# CITY OF ALBUQUERQUE

December 16, 2025

**RE: Discount Collision**  
**4000 2<sup>nd</sup> St NW**  
**Grading & Drainage Plan**  
**Engineer's Stamp Date: 11/20/2025**  
**Hydrology File: G14D100**  
**Case # HYDR-2025-00415**

Based upon the information provided in your submittal received 11/20/2025, the Grading & Drainage Plan **is not approved** for Building Permit. The following comments need to be addressed for approval of the above referenced project.

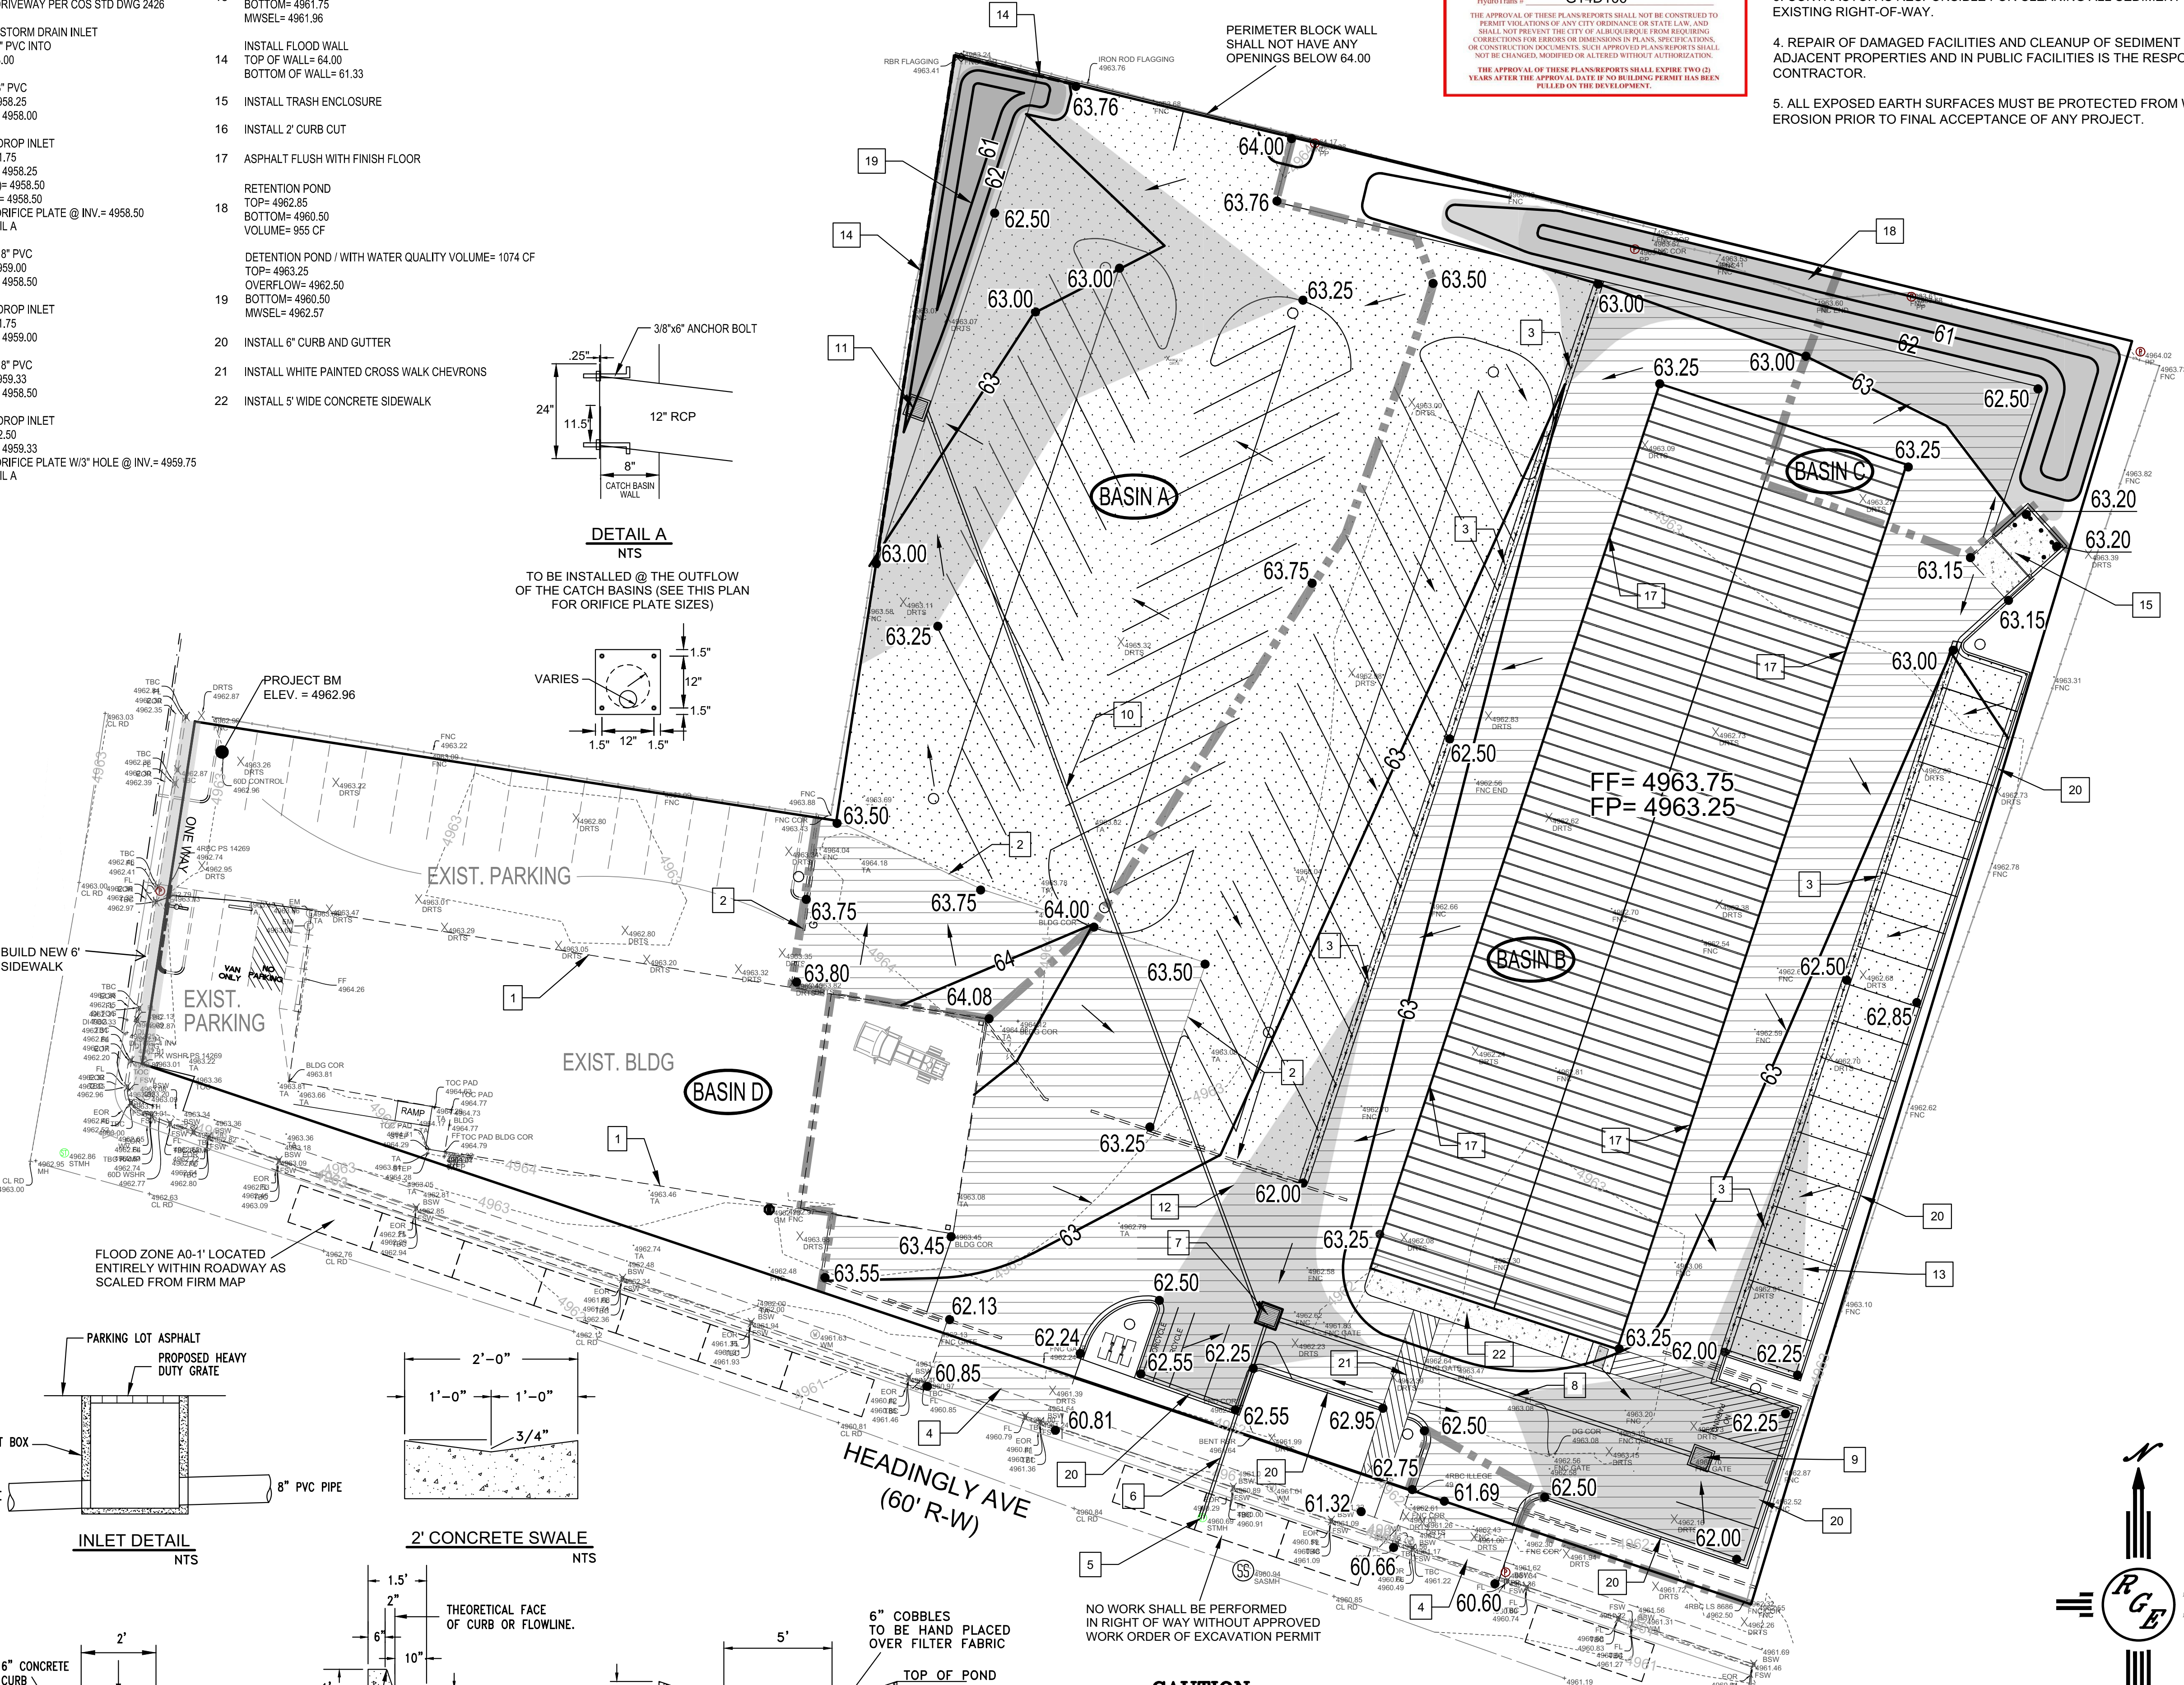
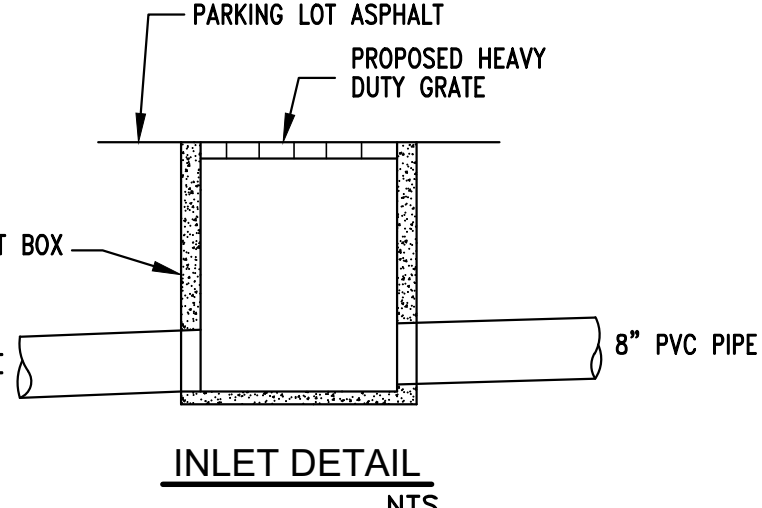
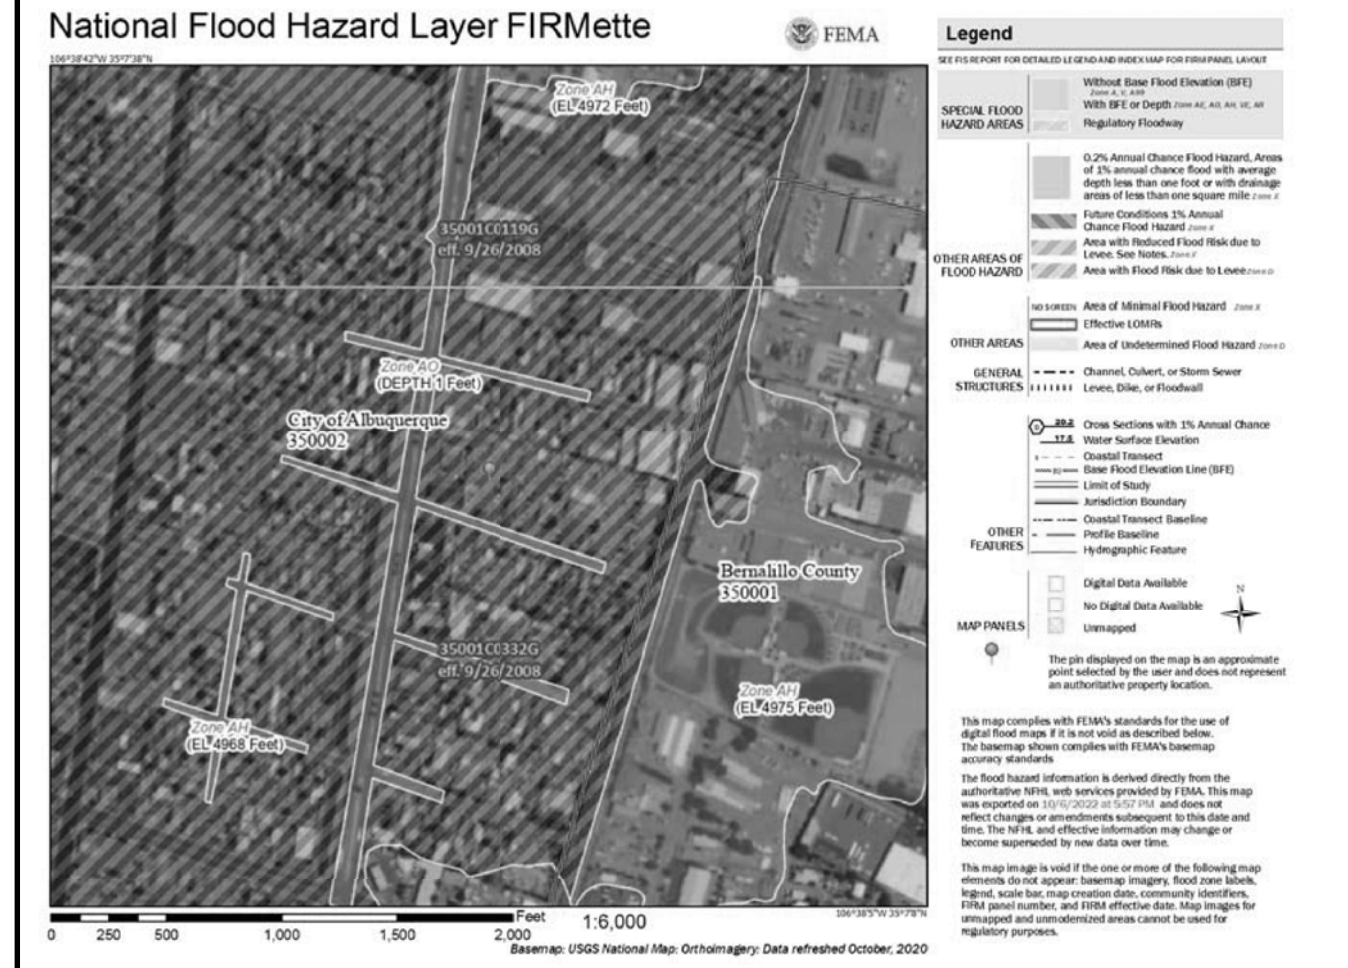
- Please provide the legal description of the property.

- Show the proposed sidewalk along 2<sup>nd</sup> Street NW.
- Please provide the Benchmark information (location, description and elevation) for the survey contour information provided.
- Please provide the FIRM Map and floodplain note with effective date.
- Show the limits of the SFHA Zone AO (1') on the plan.
- Since this site is in the Valley region, please follow Article 6-5 Valley Drainage Criteria of the DPM. The following conditions must be applied to the site:
  - Pad elevation shall be a minimum of one (1) foot above the 100 year 10-day stormwater surface elevation.
  - A permanent perimeter wall or barrier around the development is required to contain the 100 year 24 hour storm developed runoff.

8. Provide inlet calculations, including 2x capacity (50% clogging factor) for inlets in a sump.
9. Verify if a waterblock, 0.87' high, per COA Paving Detail No. 2426, at the driveway entrance will be needed due to the SFHA Zone AO(1').
10. Add note on the plan that "No work shall be performed in the public ROW without an approved Work Order or Excavation Permit".

ENGINEER'S SEAL	DISCOUNT TOWING 4000 SECOND STREET	DRAWN BY DEM
DAVID SOULE P.E. #14522	CALCULATION SHEET	DATE 10-10-22
12/2/22	 Rio Grande Engineering P.O. BOX 53294 ALBUQUERQUE, NM 87199 (505) 321-8099	DISCOUNT TOWING.DWG
		SHEET # C2
		JOB #

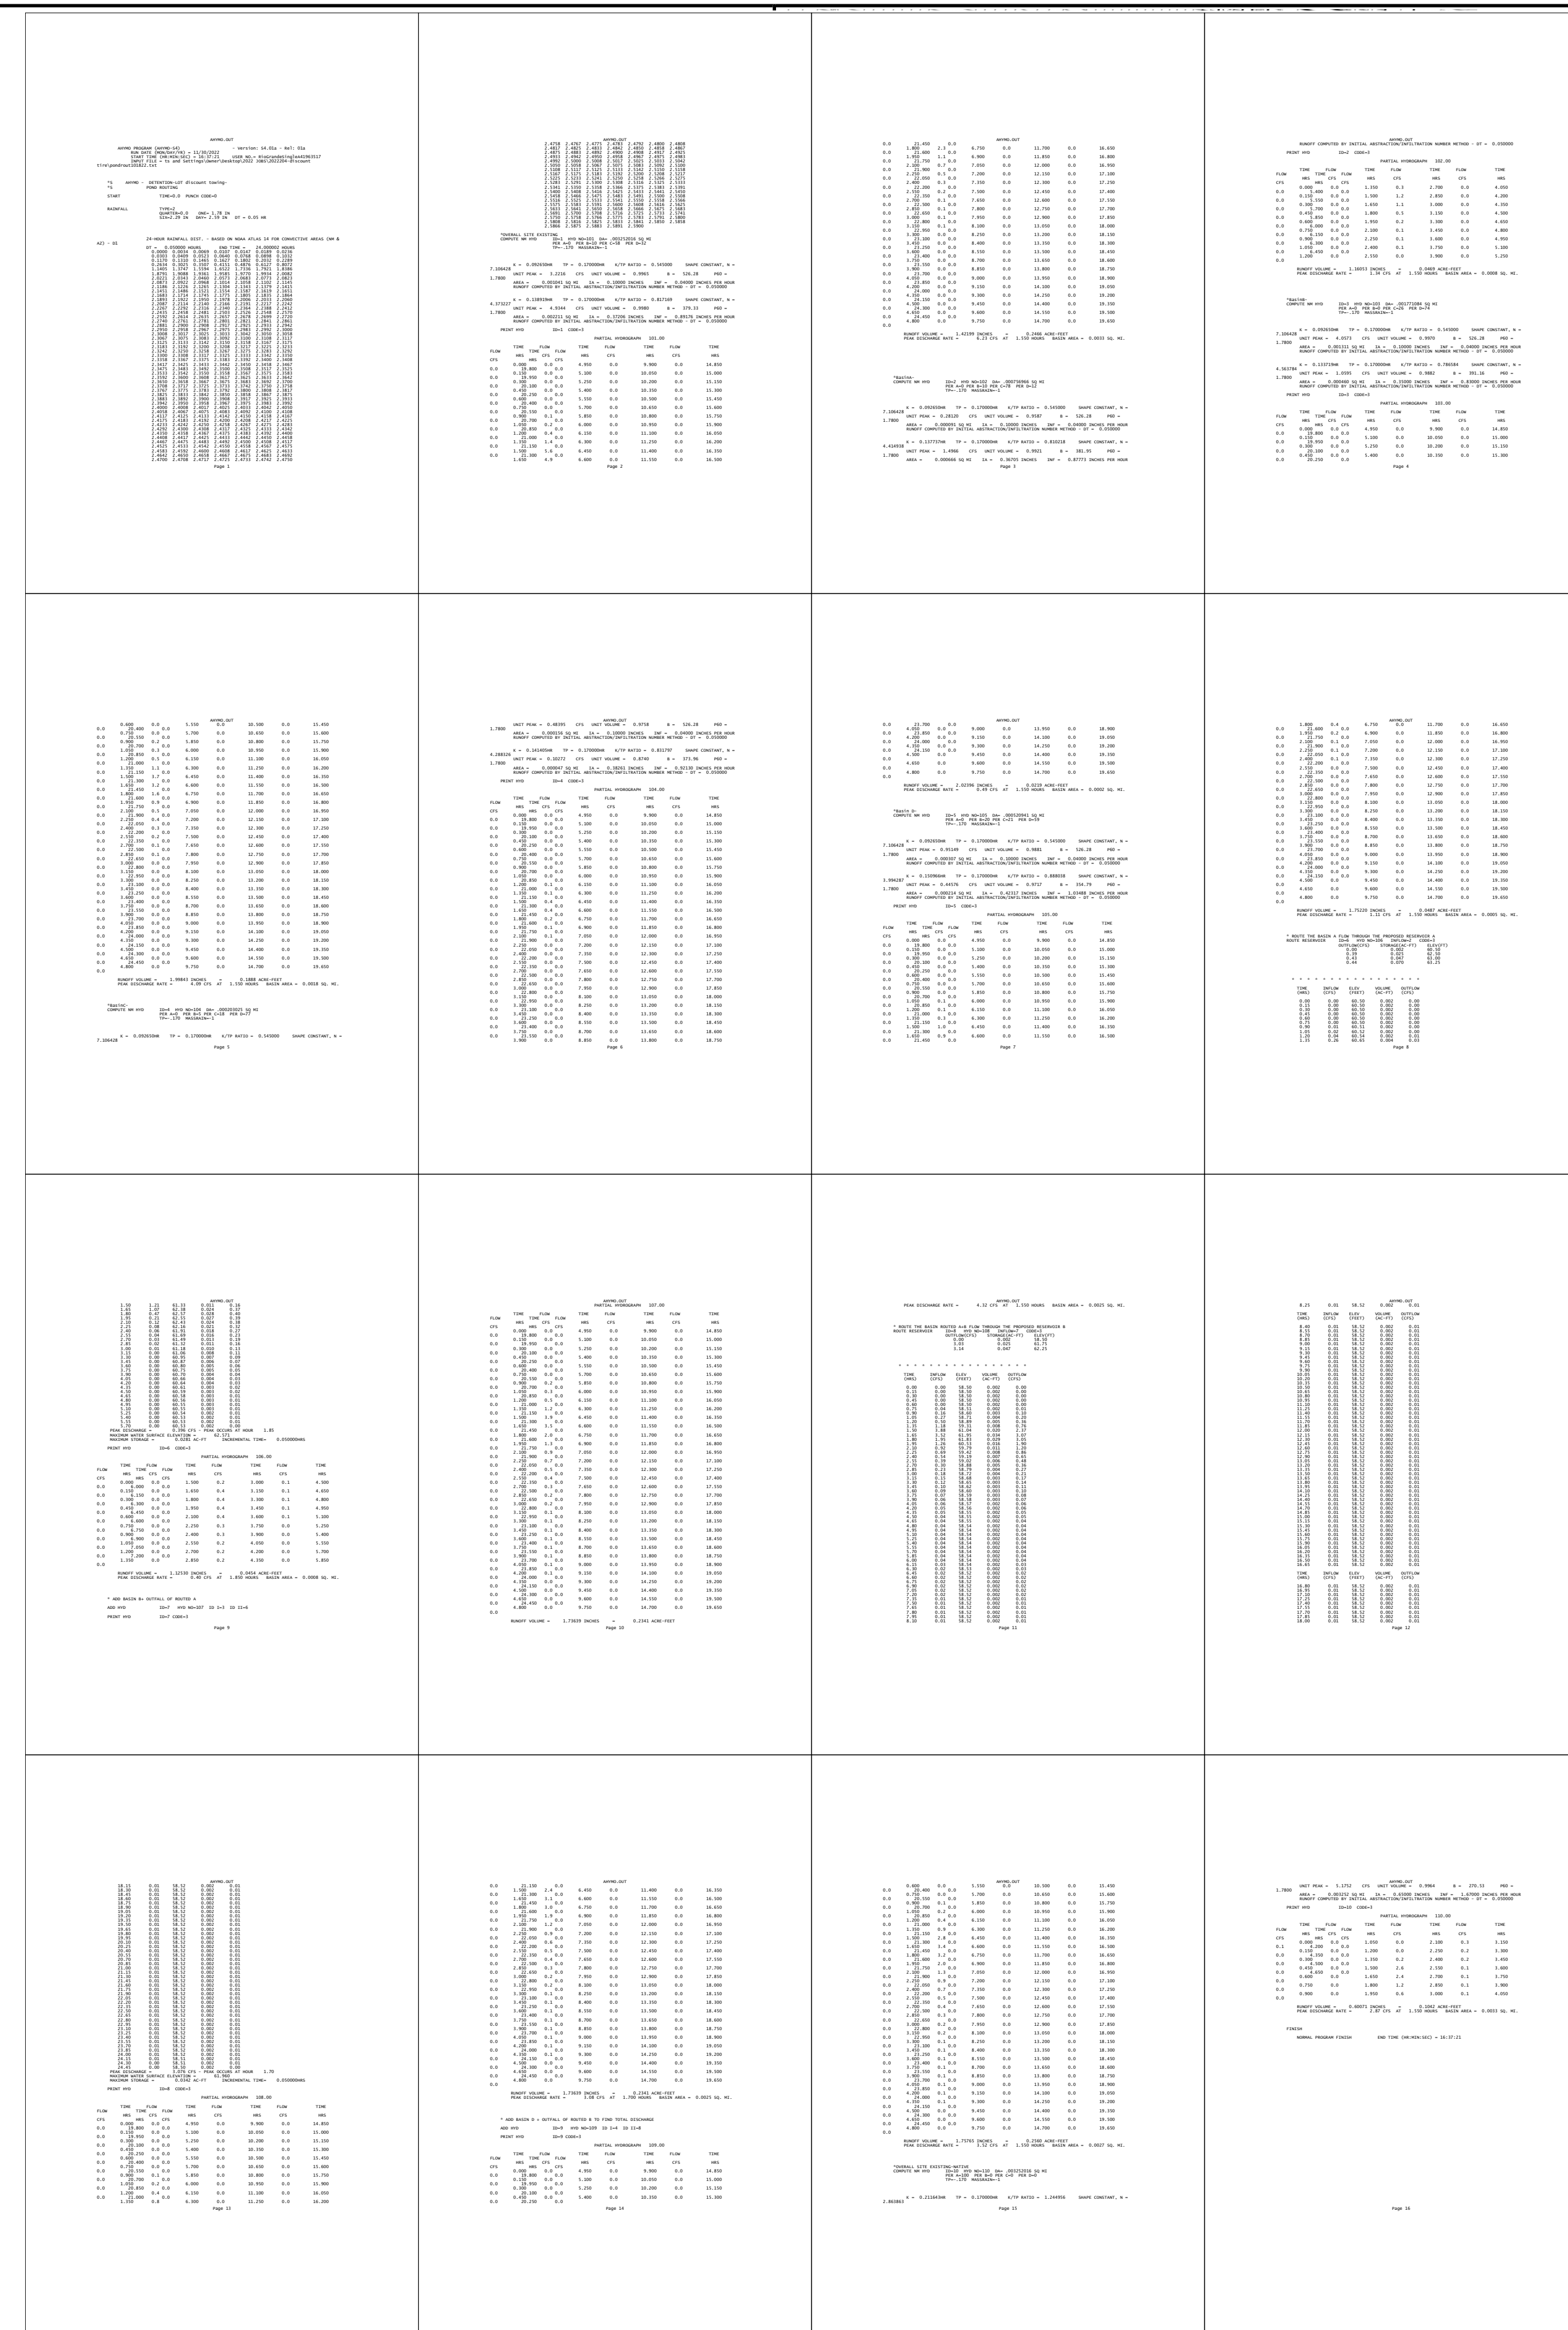
- Please correct the calculations in the table highlighted below:

Basin	Area (sf)	Area (acres)	Treatment A		Treatment B		Treatment C		Treatment D		Q100	Q100
			%	(acres)	%	(acres)	%	(acres)	%	(acres)	GENERATED	DISCHARGED
EXISTING ONSITE NATIVE	90661	2.081	100%	0.0000	0.0%	0.1216	0.0%	0.7660	0%	1.1937	2.87	2.87
EXISTING ONSITE	90661	2.081	0%	0.0000	10.0%	0.1216	58.0%	0.7660	32%	1.1937	6.23	6.23
ONSITE A	21103	0.484	0%	0.0000	10.0%	0.0484	78.0%	0.3779	12%	0.0581	1.34	0.40
ONSITE B	49375	1.133	0%	0.0000	0.0%	0.0000	26.0%	0.2947	74%	0.8388	4.09	3.08
ONSITE C	5660	0.130	0%	0.0000	5.0%	0.0065	18.0%	0.0234	77%	0.1001	0.49	0
ONSITE D	14523	0.333	0%	0.0000	20.0%	0.0667	21.0%	0.0700	59%	0.1967	1.11	1.22
